OXFORDSHIRE COUNTY COUNCIL'S RESPONSE TO CONSULTATION ON THE FOLLOWING DEVELOPMENT PROPOSAL

Application no: 22/03763/SCOP

Proposal: Scoping Opinion with respect to the scope and methodology of the Environmental Impact Assessment (EIA) in relation to re-development proposals of approximately 170 hectares (Ha) land at the existing Begbroke Science Park and surrounding land. The findings of the EIA will be reported in an Environmental Statement (ES) which will accompany the planning application

Response Date: 12th January 2023

Figure 1.2: Indicative Planning Application Boundary

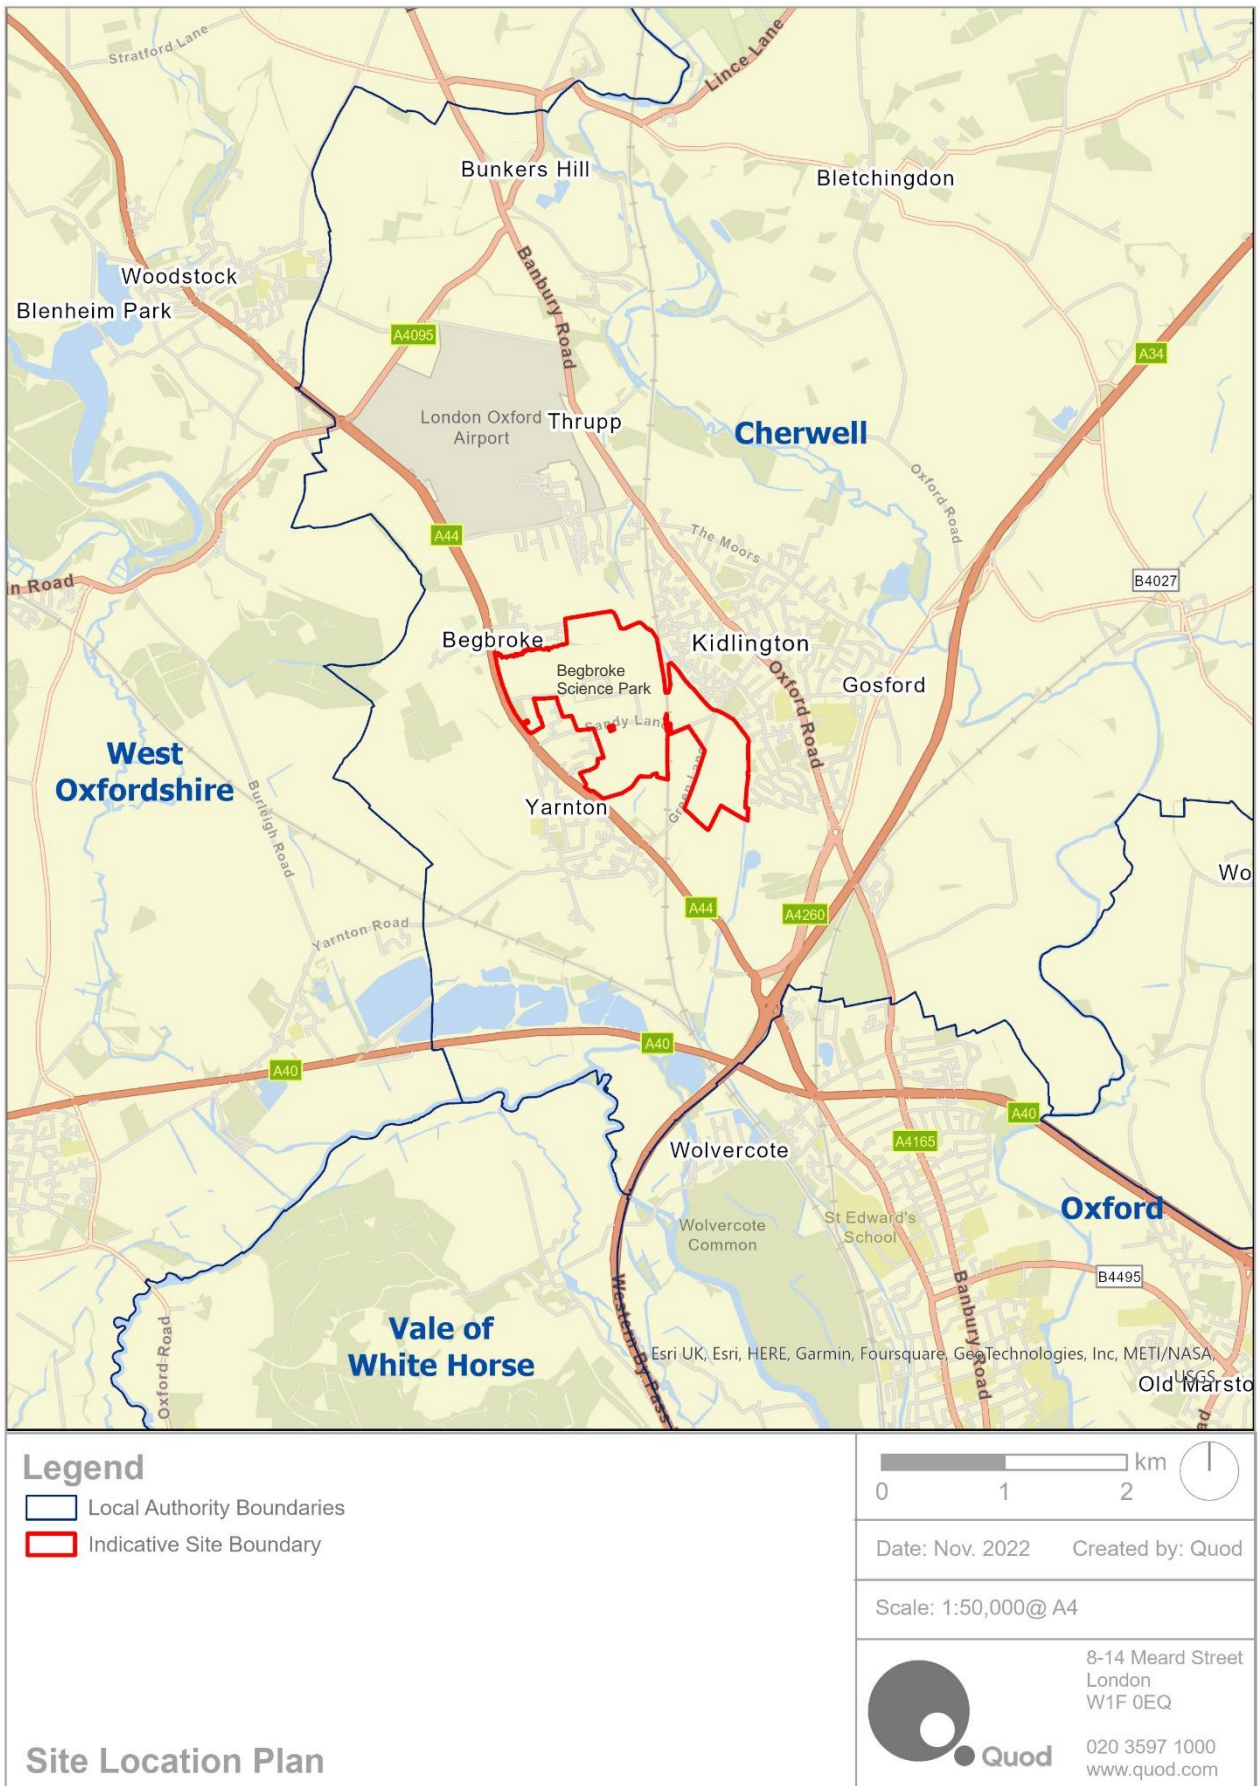
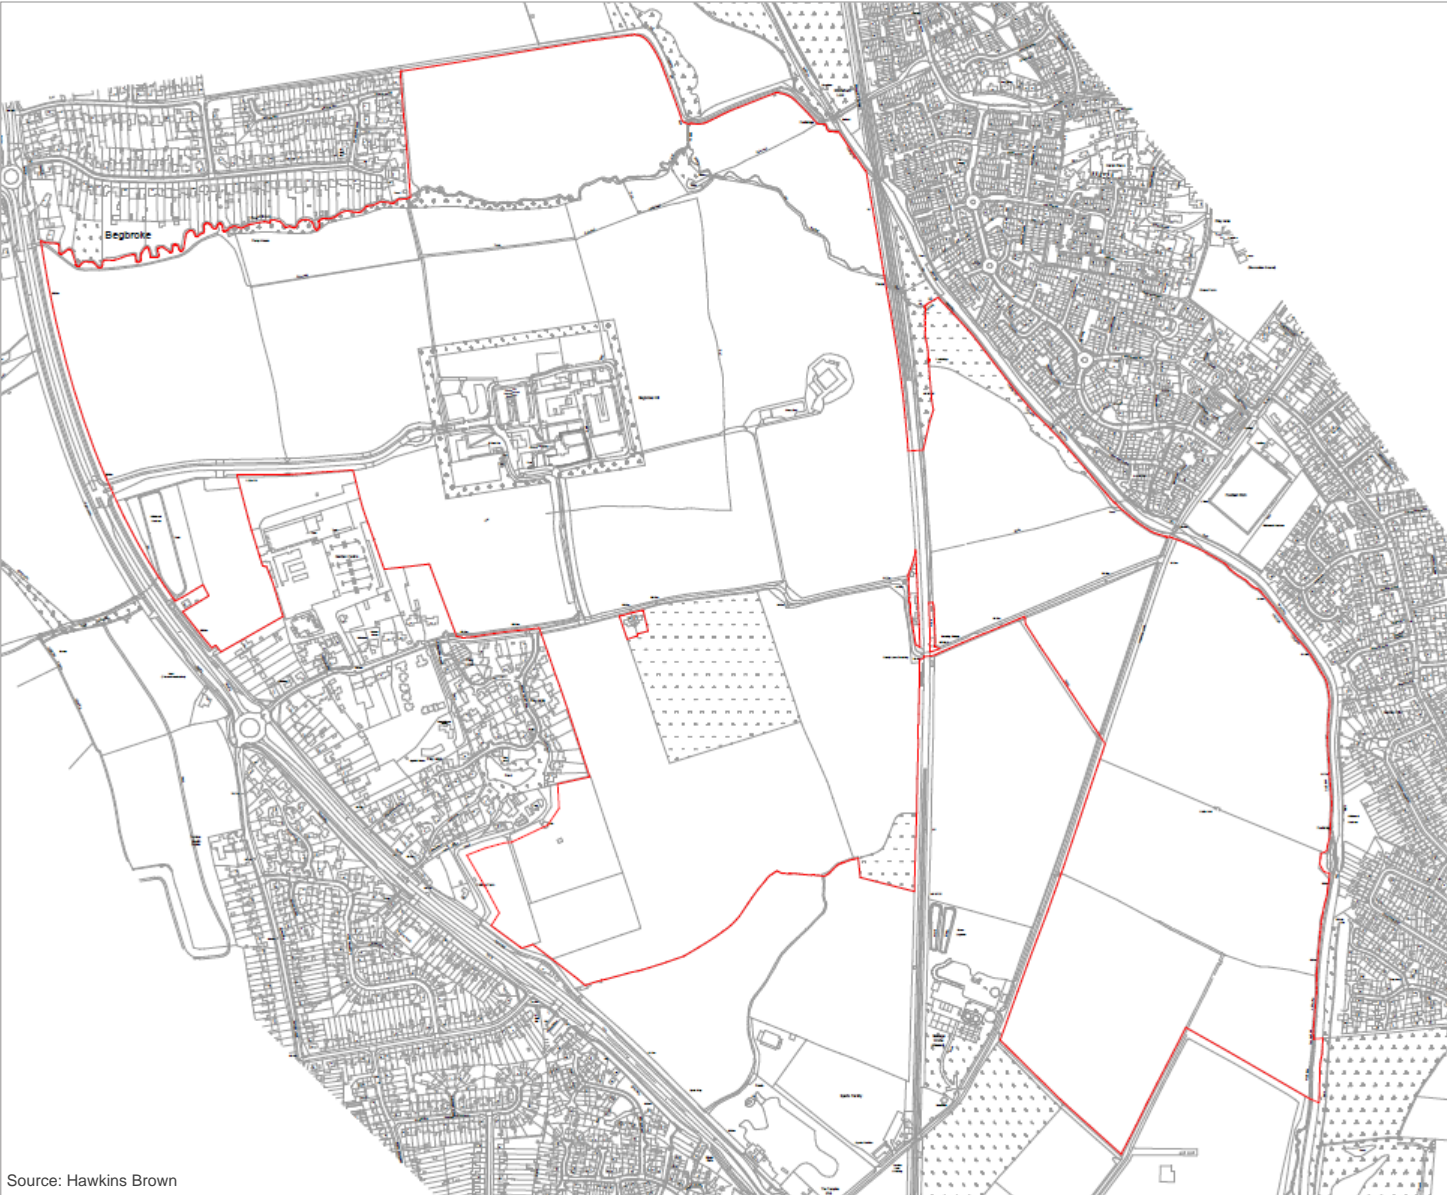
The 170ha site identified in figures 1.1 and 1.2 as the indicative planning application boundary, includes land which has been taken out of the Green Belt, and land which is retained within the Green Belt. It also encompasses the existing Begbroke Science Park. Although it is unfortunate that a single planning application covering the entire site with its different landowners is not proposed, we welcome the inclusion of all the land that OUD owns in the application. The Development Brief will help with providing a more comprehensive understanding of all the 190ha PR8 allocated site including land in other ownerships.

Figure 5.3: Extent of North Oxford VISSIM micro-simulation model

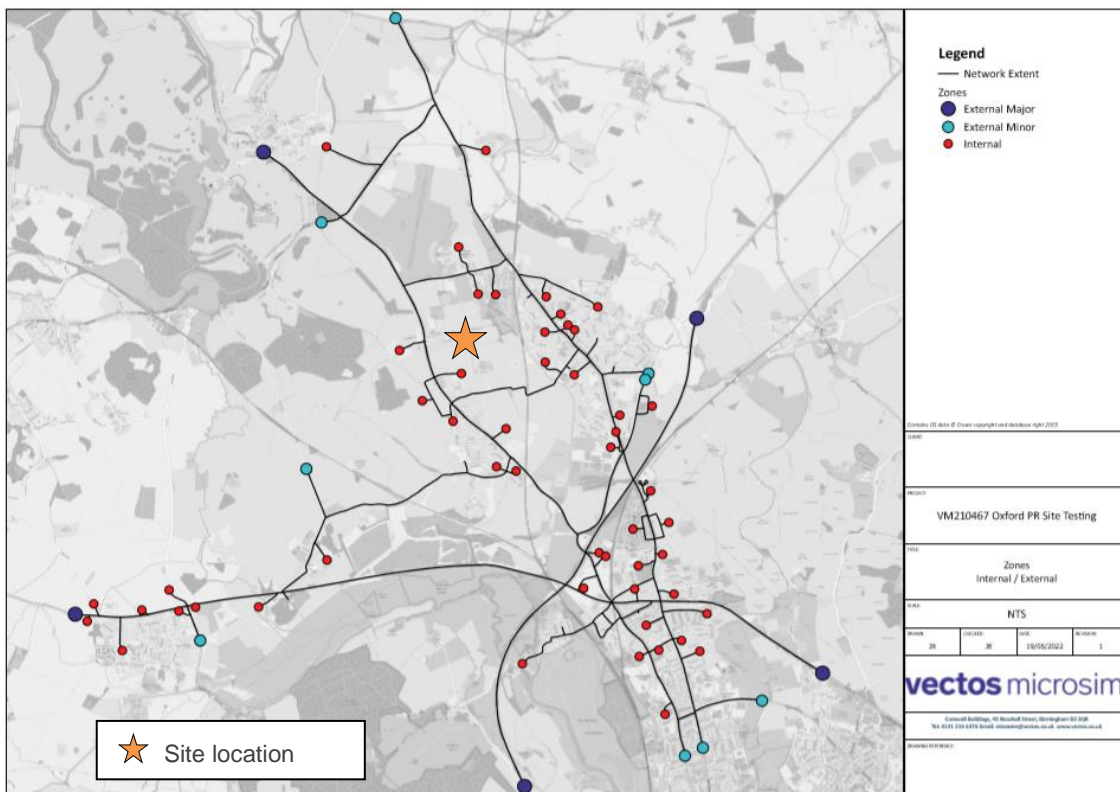
The study area and special scope for the area is agreed and is based upon the North Oxford VISSIM model extents.

Figure 1: Cumulative Schemes

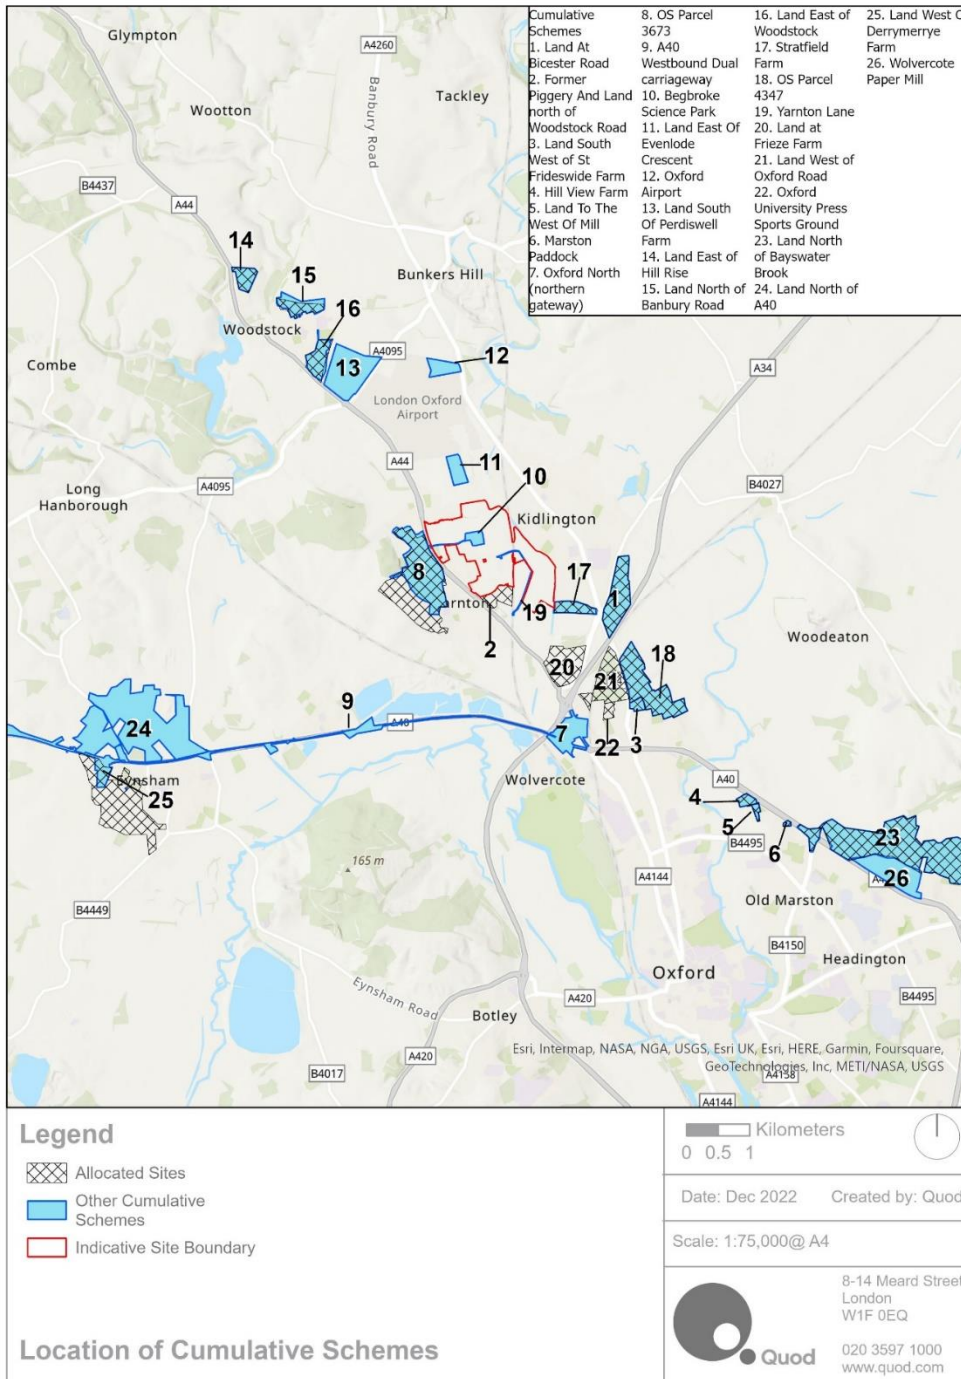
In Appendix A of the scoping report, which lists nearby developments, application 21/01695/FUL for Thornhill Park, which received approval from the City Council Planning Committee on 13/12/22 should also be noted, alongside the Nielson House development adjoining which has been implemented.
